Addition of first floor to existing bungalow to allow conversion to 2 x 1 bedroom flats and a studio flat.

38 Chalcraft Lane Bersted

Thank you for your internet comments made on 22nd May 2019 which has been recorded as '**an objection**' with the comments as follows:

**PROPOSED
ELEVATIONS**

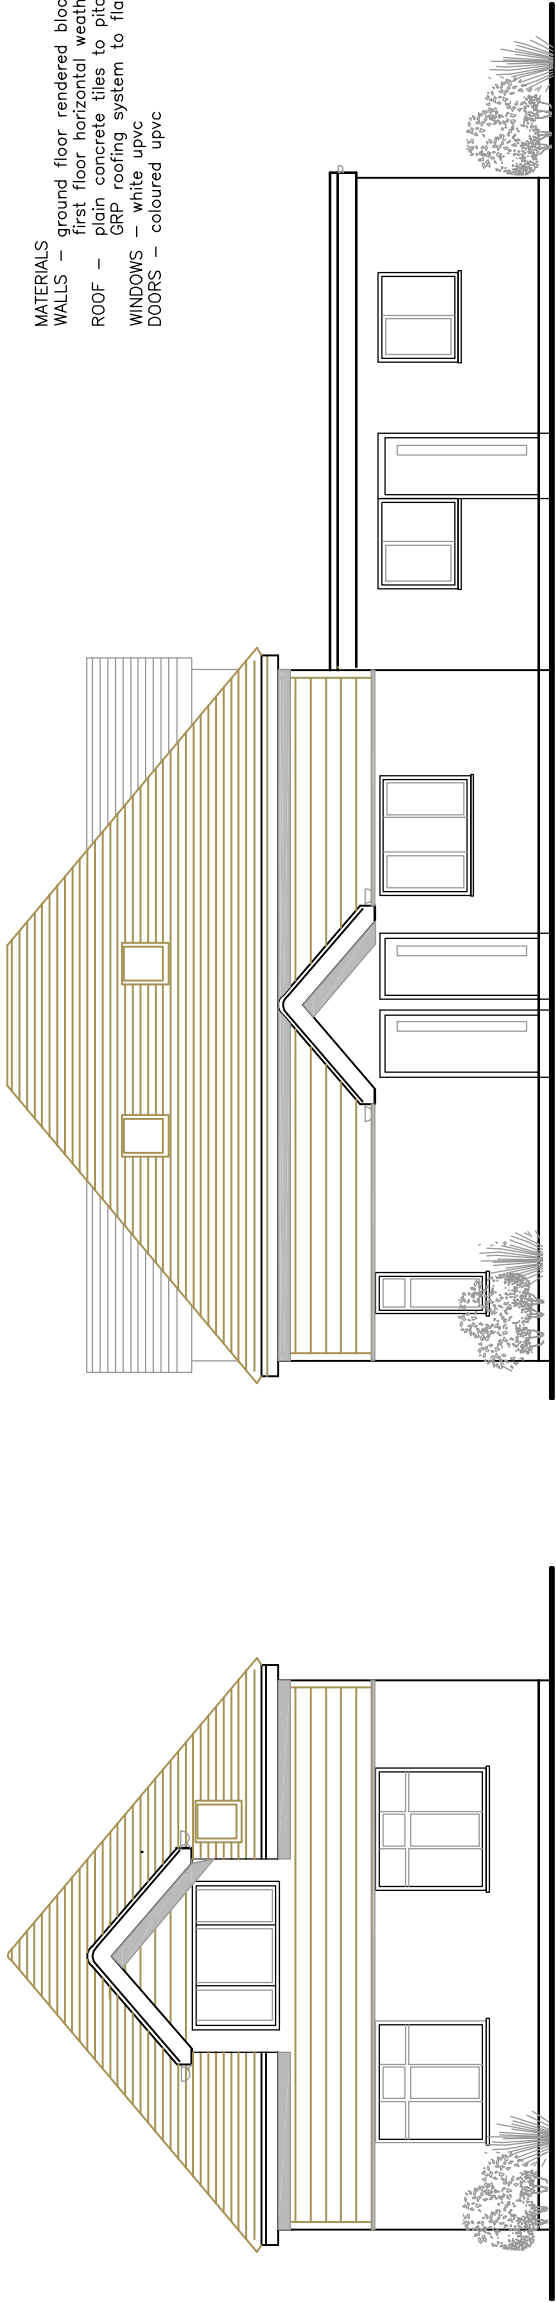
Does not conform to Arun Local Plan Policy DDM4 the dormer windows overlook neighbouring properties, siting of bin and cycle stores up to the neighbouring boundary, amenity space for 3 flats look in adequate. A general overdevelopment of the existing site. Does not comply with Bersted Neighbourhood Development Plan Policy HDQ8 for the minimum of 2 parking spaces per dwelling
